From: Anita Gardner
Sent: 21 March 2012 09:48
To: Planning.Responses
Subject: FW: FG/6/12 - Application for conversion of barn and annexe to 2 residential units The Old Barn, Ferringham Lane, Ferring

From: Ian Brewster
Sent: 20 March 2012 16:57
To: Anita Gardner
Subject: RE: FG/6/12 - Application for conversion of barn and annexe to 2 residential units The Old Barn, Ferringham Lane, Ferring

Figure 2. ~ Protective fencing for RPA

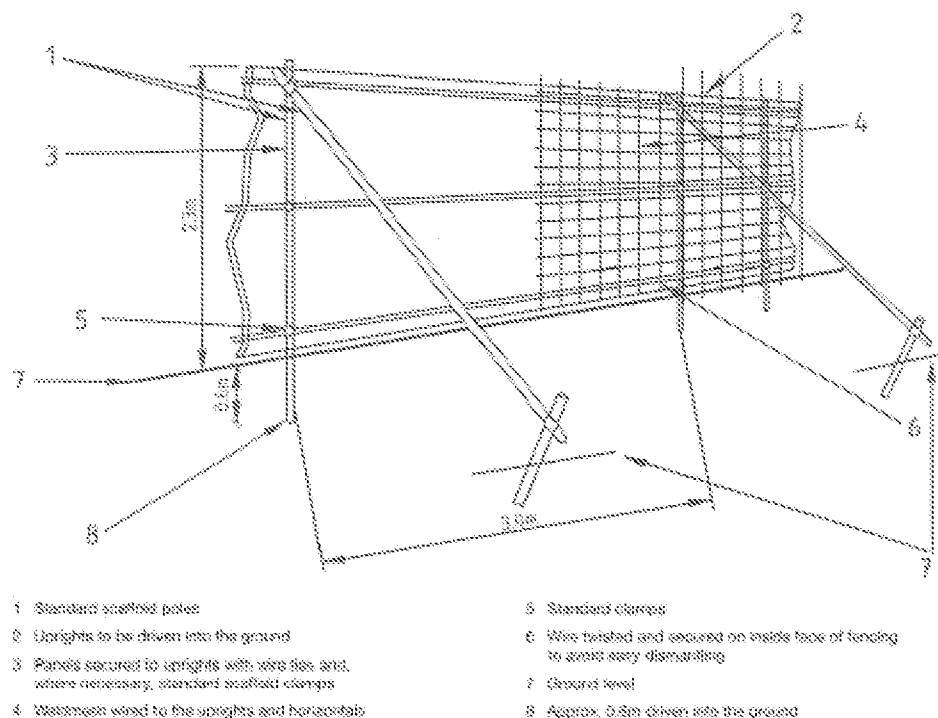
The tree consultant suggests that the fencing should be supported within rubber feet as part of the protection. It should be possible however to break through the thin concrete layer to insert scaffold tubes to form a rigid attachment point for an appropriate weldmesh panels in accordance with 'BS5837 Section 9.2 Barriers'.

Proposed Landscape Scheme - Plan - GA

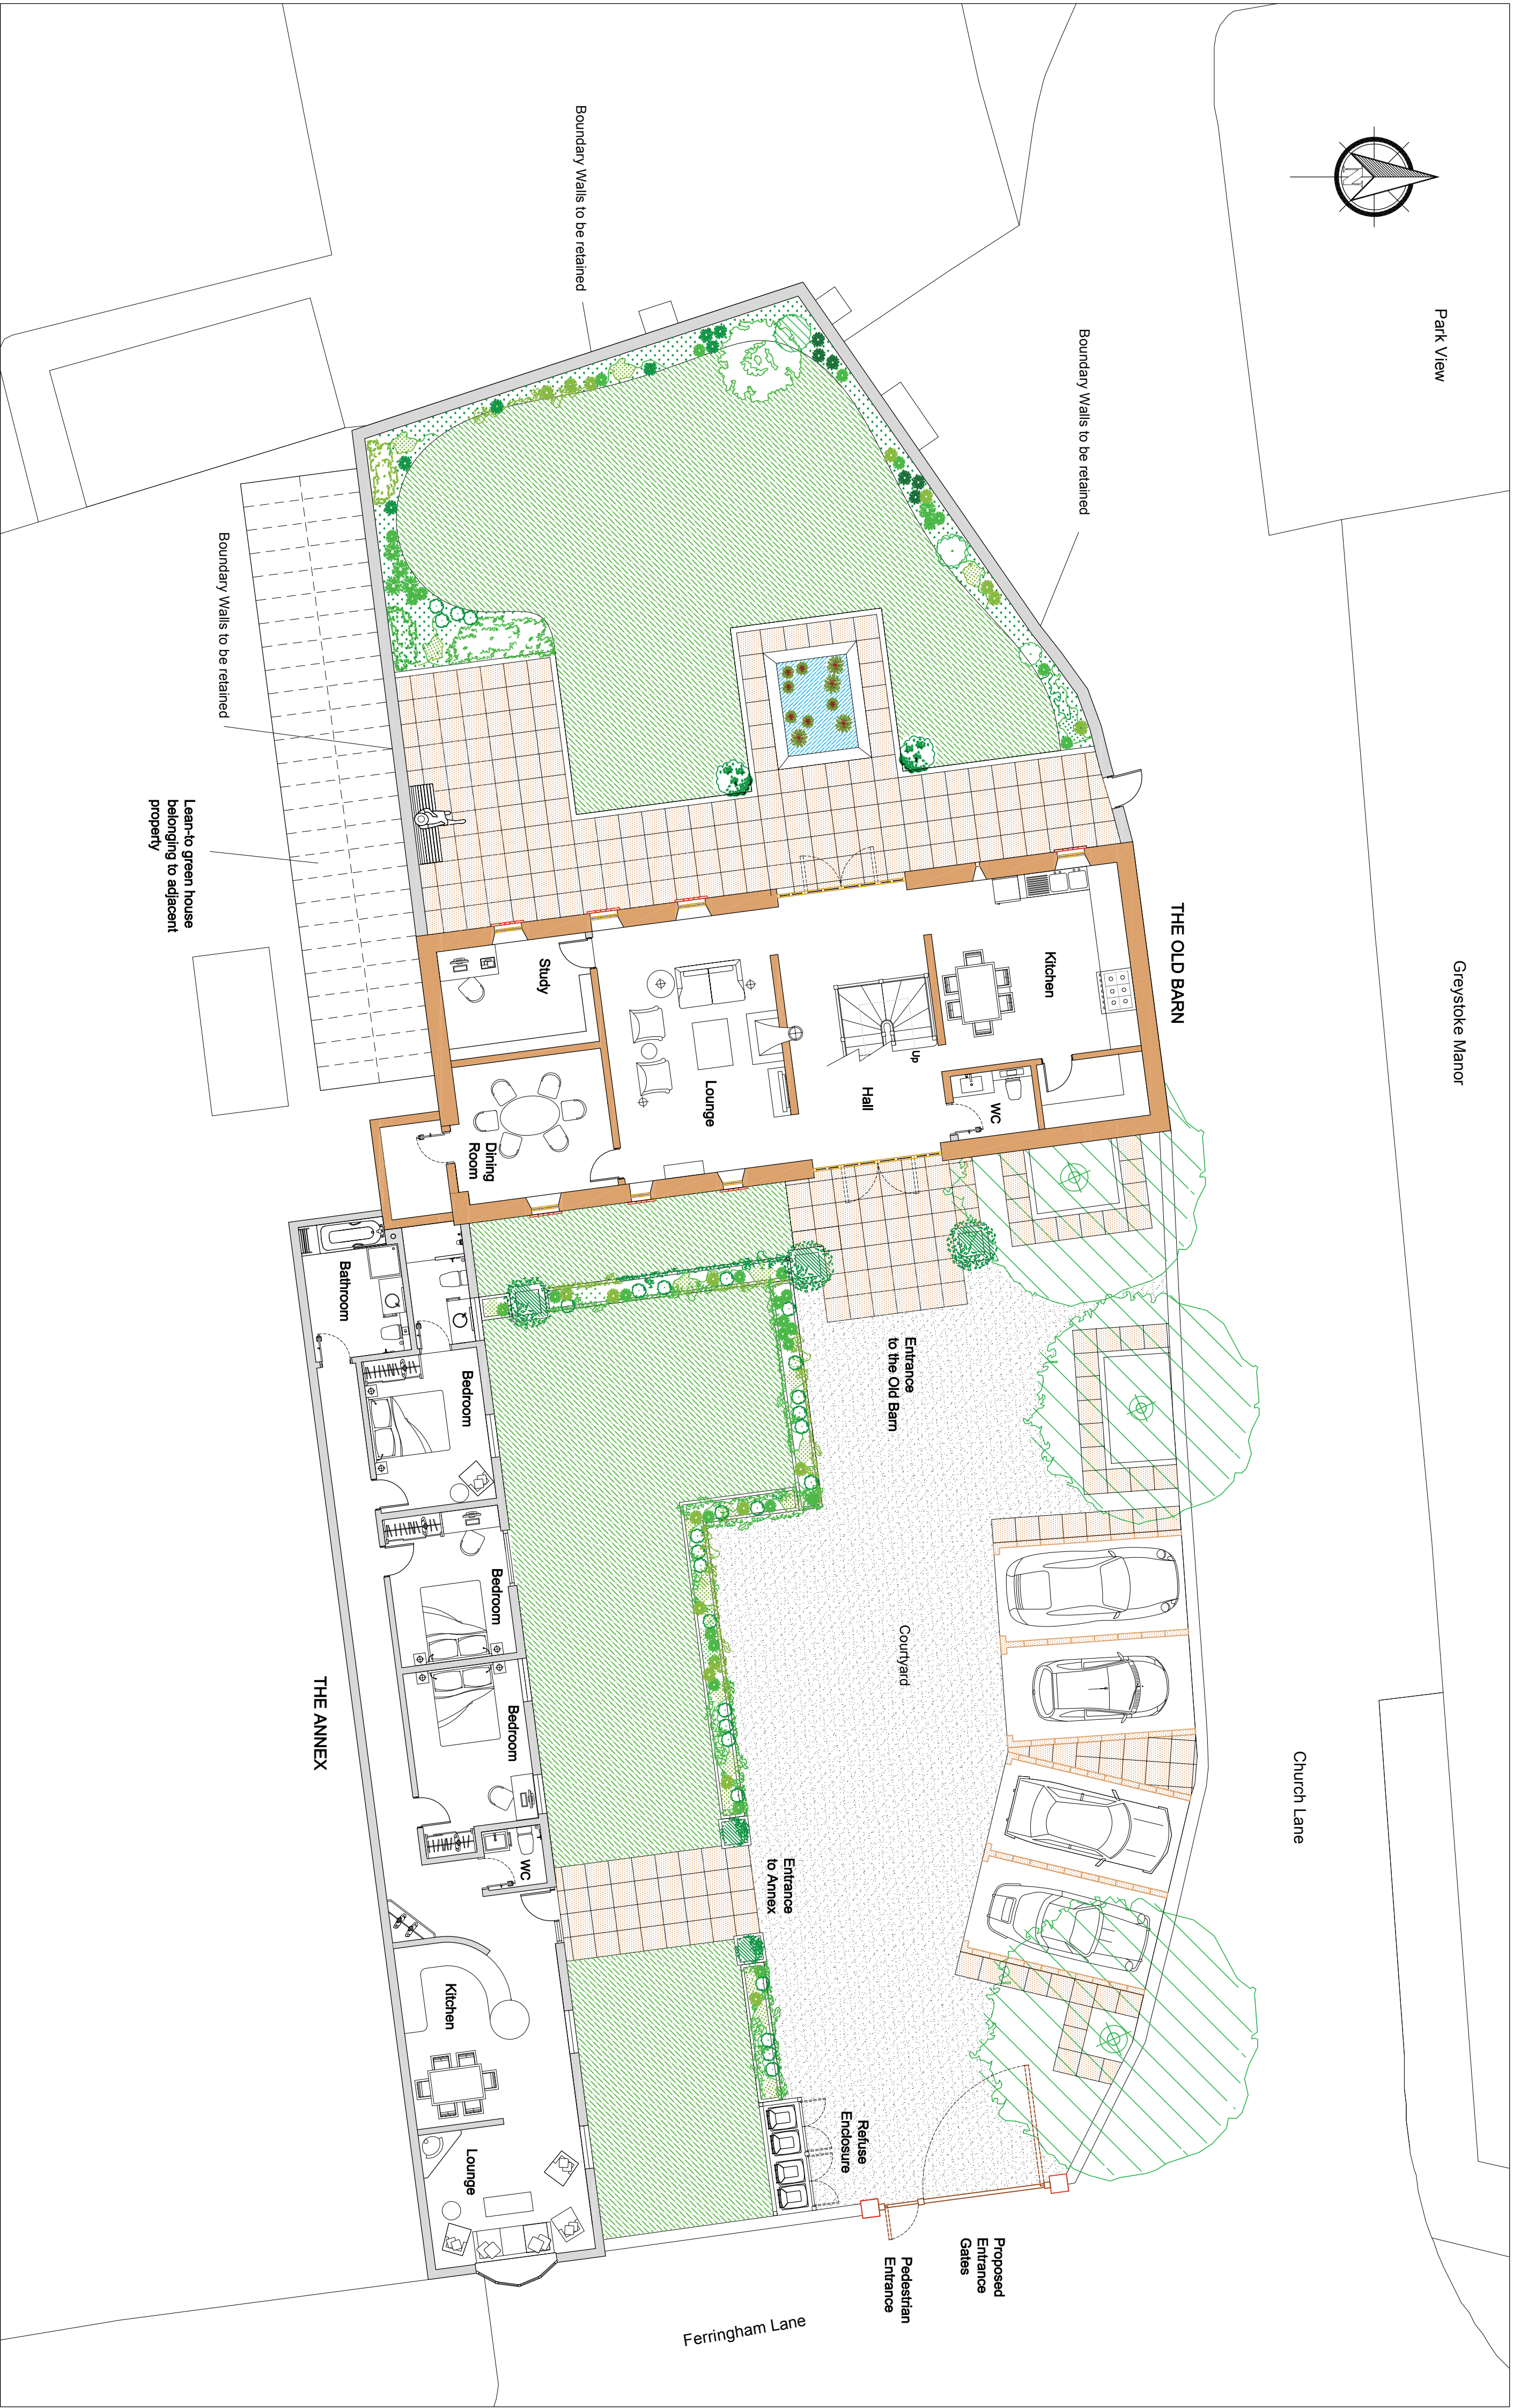
The change of use to residential dwelling will require access for non commercial vehicles. The broken and uneven concrete surface would become an issue for new owners regarding the unevenness for lighter vehicles and potential trip hazards. The concrete should therefore be removed manually and carefully within the Root Protection Area (RPA). A three dimensional cellular confinement system (BS5837 Section 11.8) should replace the concrete to provide a new access route and parking spaces where it encroaches into the RPA, restricting a maximum of 3 car parking bays positioned centrally between both T2 and T3. The three dimensional cellular confinement system should be installed after the bulk of the main property construction is complete. The tree consultant states no contaminants and materials to be stored or fires to be lit near to the trees which are important considerations and should be addressed with the Planning conditions.

According to 'FEBO designs' the trees have been represented with small crowns. However they are substantially larger in size and would have a bearing upon the overall design and impact upon the future health and existence of both T2 and T3.
